Addendum Number One

Drawings and Specifications Dated August 17, 2007

Portland Harbor Hotel Annex

468-470 Fore Street

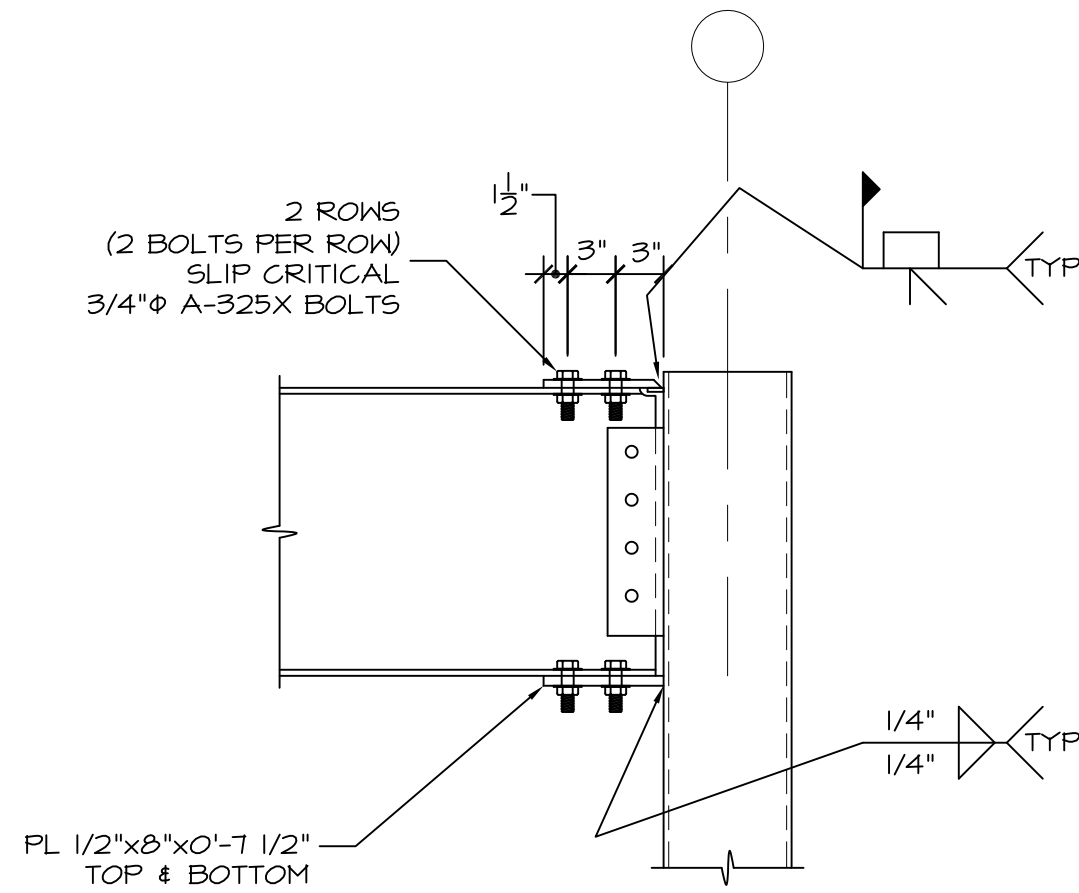
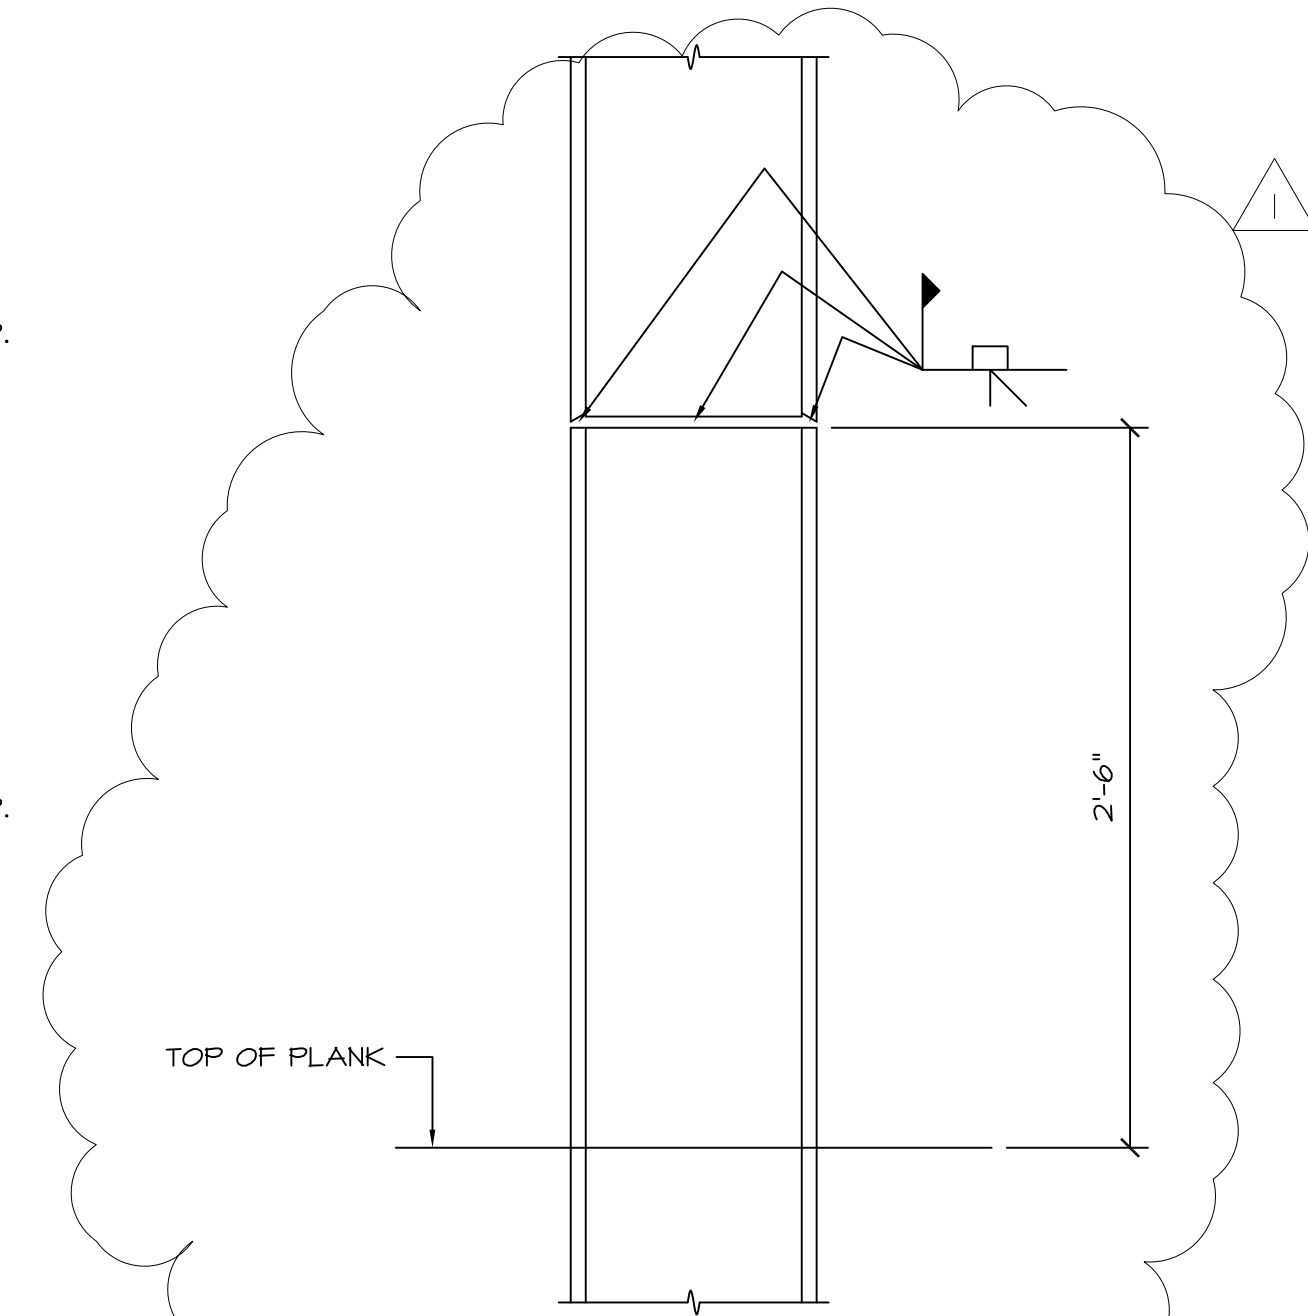
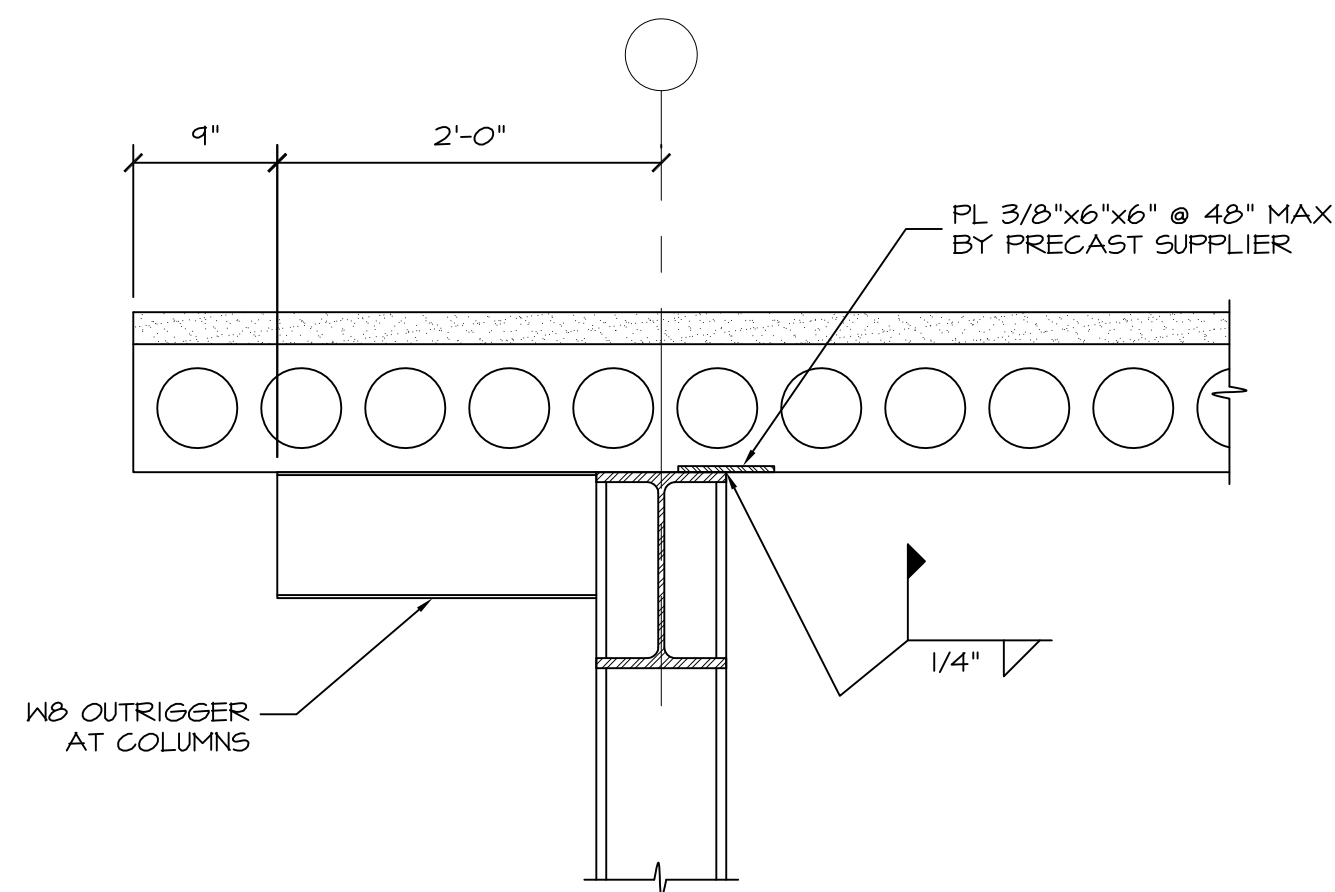
23. **Modification:** SHEET S7 - Roof Framing Plan; omit W12x26 spanning from 2-A to 2-C. Add HSS4x4x0.1875 at 2-B. Add W8x10 from 2-A to 2-B.
24. **Modification:** SHEET S9 - Column Schedule & Framing Details; Revise Column Schedule to indicate an HSS4x4x0.1875 at grid 2-B with bottom of Base Plate at elevation 113’-9” and top of column at elevation 146’-7”.
